From: Liz Rogers [REDACTED]
Sent: 24 January 2018 15:09
To: Planning.Responses
Subject: RE: Planning Consultation on: A/219/17/PL

App No: A/219/17/PL

Address: Land East of Windy Ridge Mayflower Way Angmering BN16 4AY

Proposal: 12No. Social dwellings for Angmering Community Land Trust, including two communal bike stores, a pedestrian mews and orchard. Departure from the Development Plan.

T1 - G12 Tree numbers

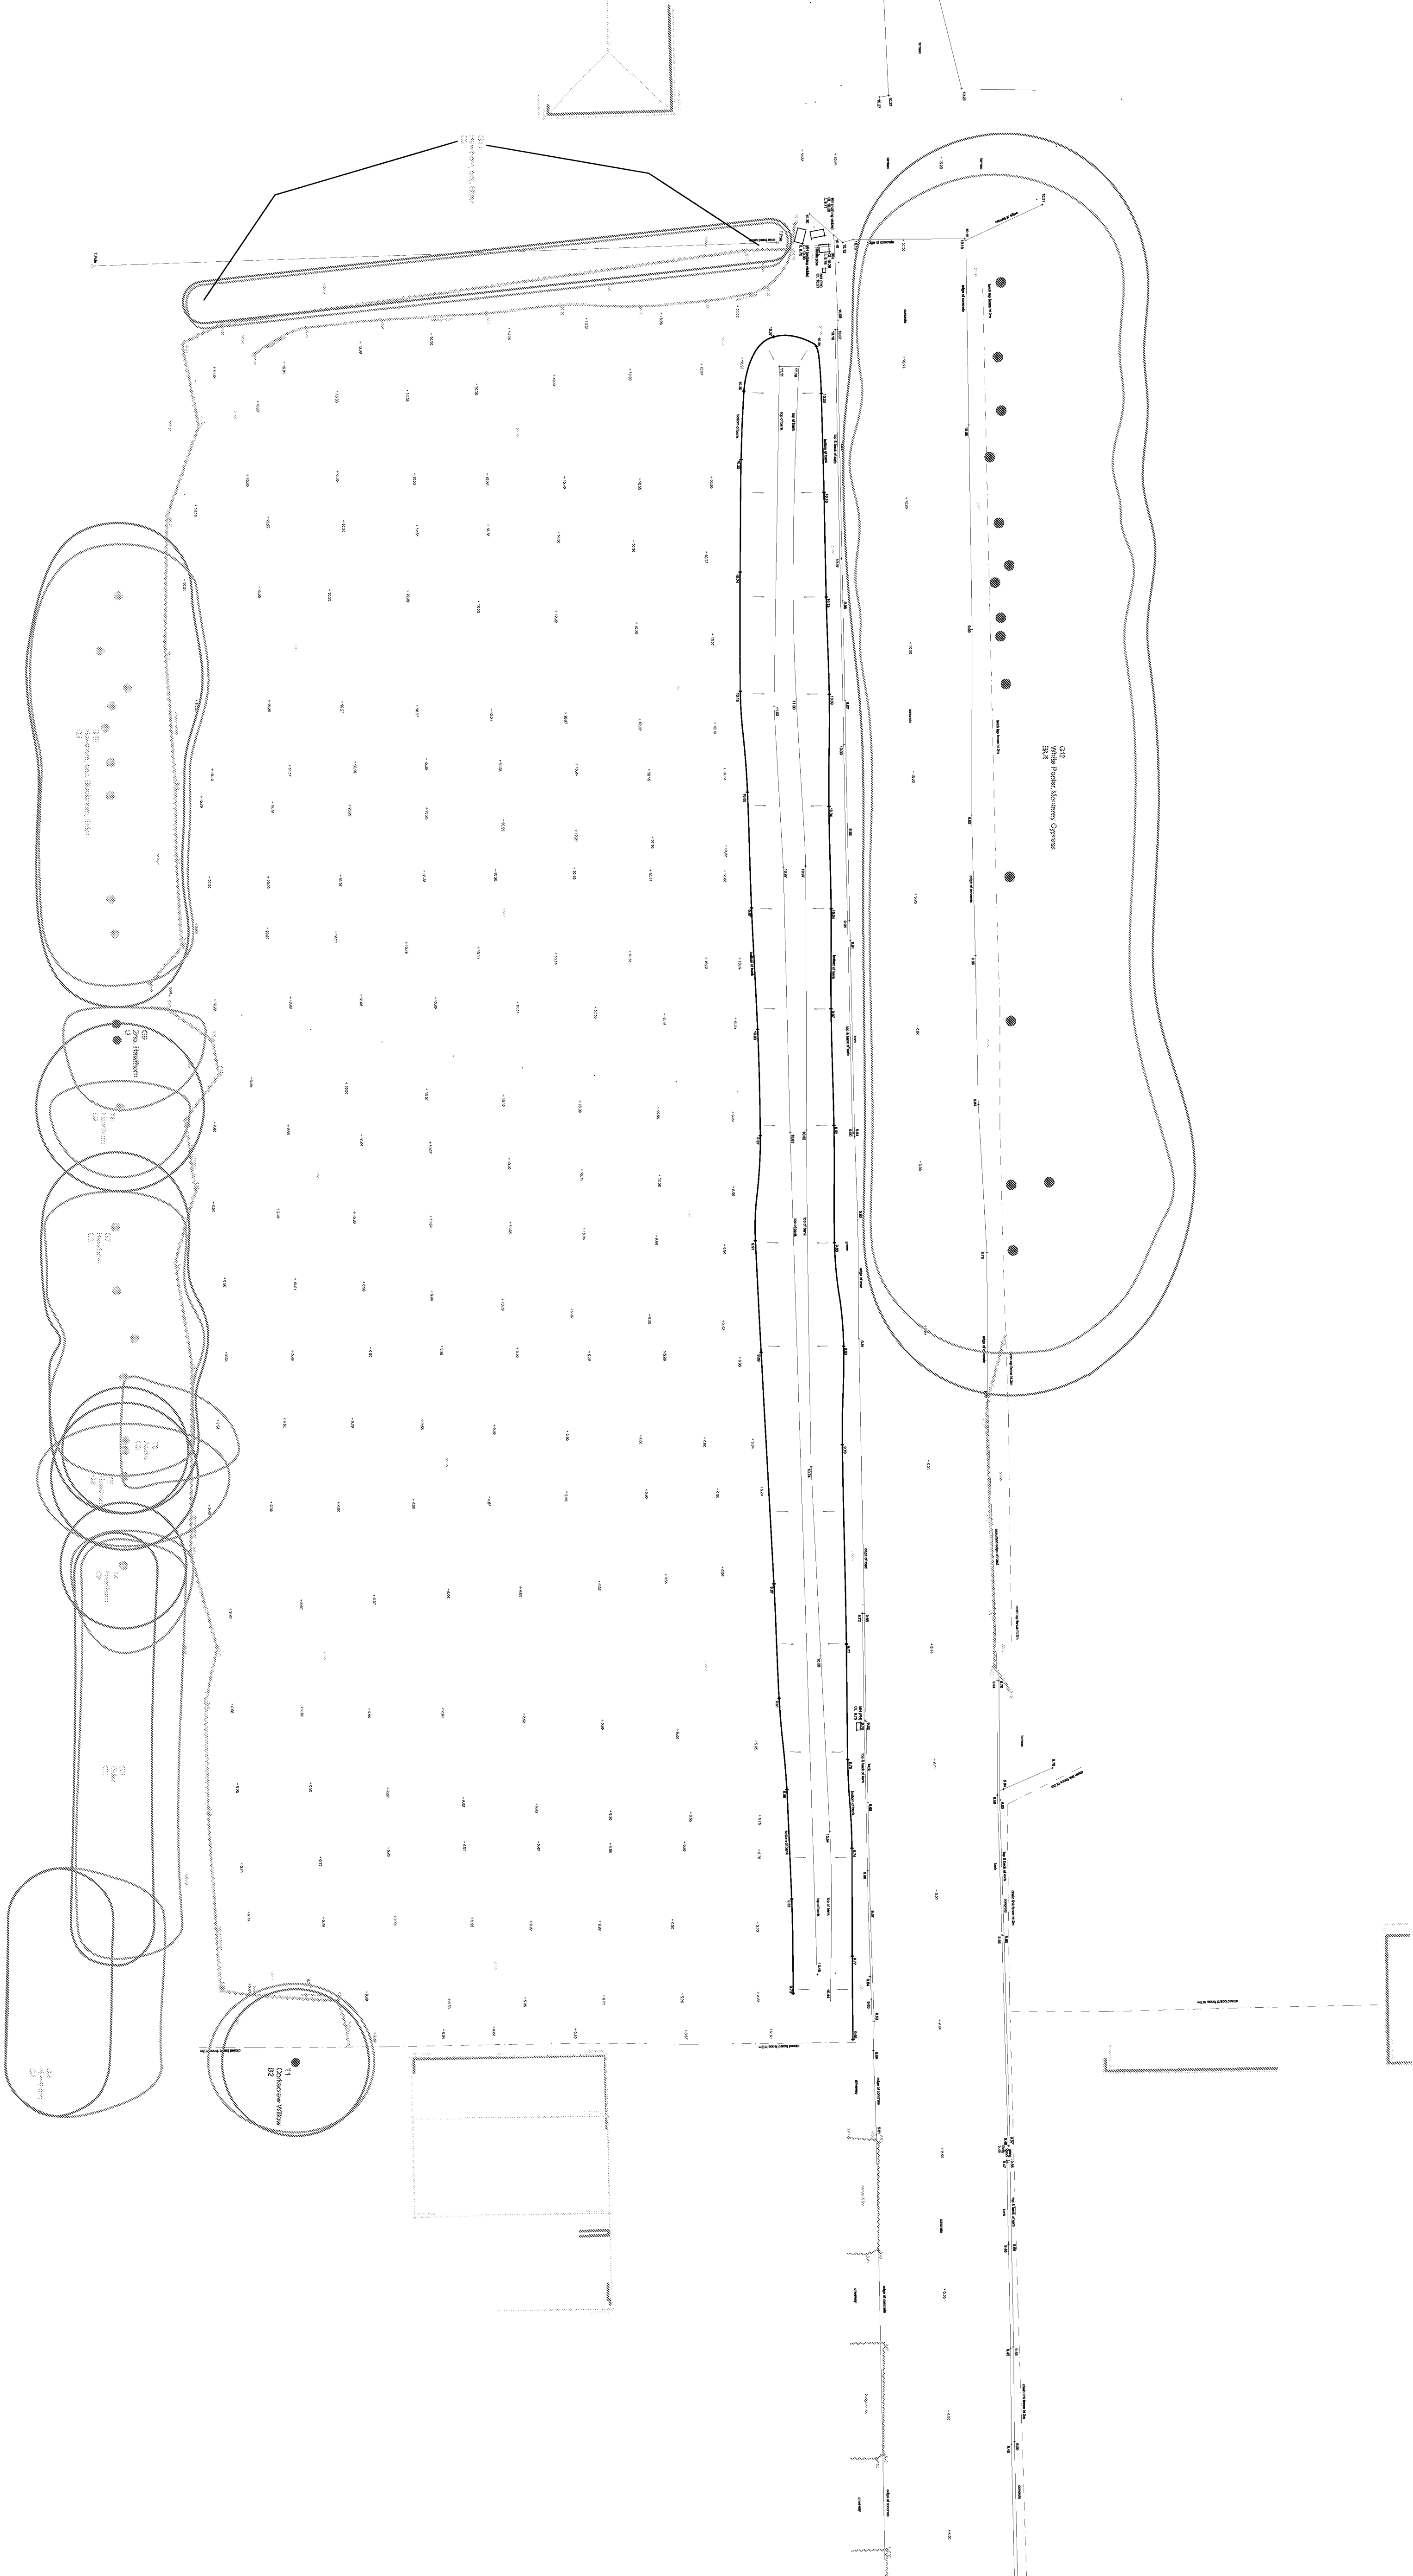
The hedgerows and trees on site are used by bats for commuting and foraging and will need to be retained and enhanced for bats. This will include having a buffer strip around the hedgerows (5m) and during construction fencing should be used to ensure this area is undisturbed. Any gaps should also be filled in using native hedge species to improve connectivity. Where any hedge is to be removed at detailed within the survey, new hedgerow should be planted. Conditions should be used to ensure this.

If any trees need to be removed further activity surveys for bats will be required.
